From: Sarah Ackerman [REDACTED]
Sent: 04 March 2022 12:14
To: Harry Chalk <Harry.Chalk@arun.gov.uk>
Subject: Re: EP/6/22/CLP

Application Ref PP-10568414v1

I am writing to confirm that I wish to withdraw my planning application, dated 22 January 2022, for permitted development at 11 Somerset Road, East Preston, Littlehampton, BN16 1BZ. The application was for a hard standing area in the back garden in order to place a mobile home. Due to problems with connecting to drainage I am no longer able to go ahead with this project.

PLAN

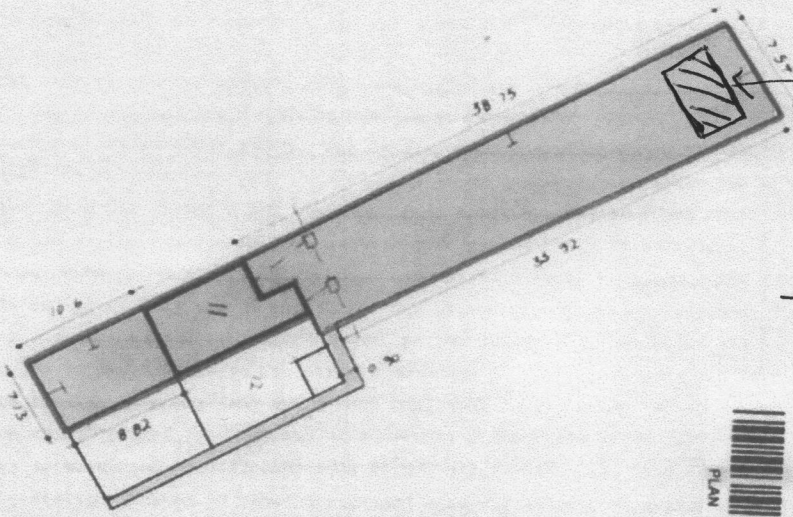
I've touched on your application with my supervisor and he has asked me to request a more accurate/ specific block plan. Sorry to have to ask this of you again but the exact location of the proposal will be a large factor in judging its compliance with permitted development. Could I request a block plan that shows the specific location of the hardstanding with measurements annotated that show its separation distance from the site boundaries?

I have just reviewed the plans submitted alongside your application and I am uncertain as to where abouts the proposal is to be situated. The description refers to the location of the hardstanding to be at the rear of the property however, the orientation and or specific whereabouts at the rear are uncertain. Could I request that the precise location and orientation of the hardstanding be added to the location/block plans and submitted to me? Many thanks.

Please find attached the plan with the area where the hardstanding and cabin will be situated. I did think that this was included in the application, stating that it would be at the end of the garden, facing towards the house.
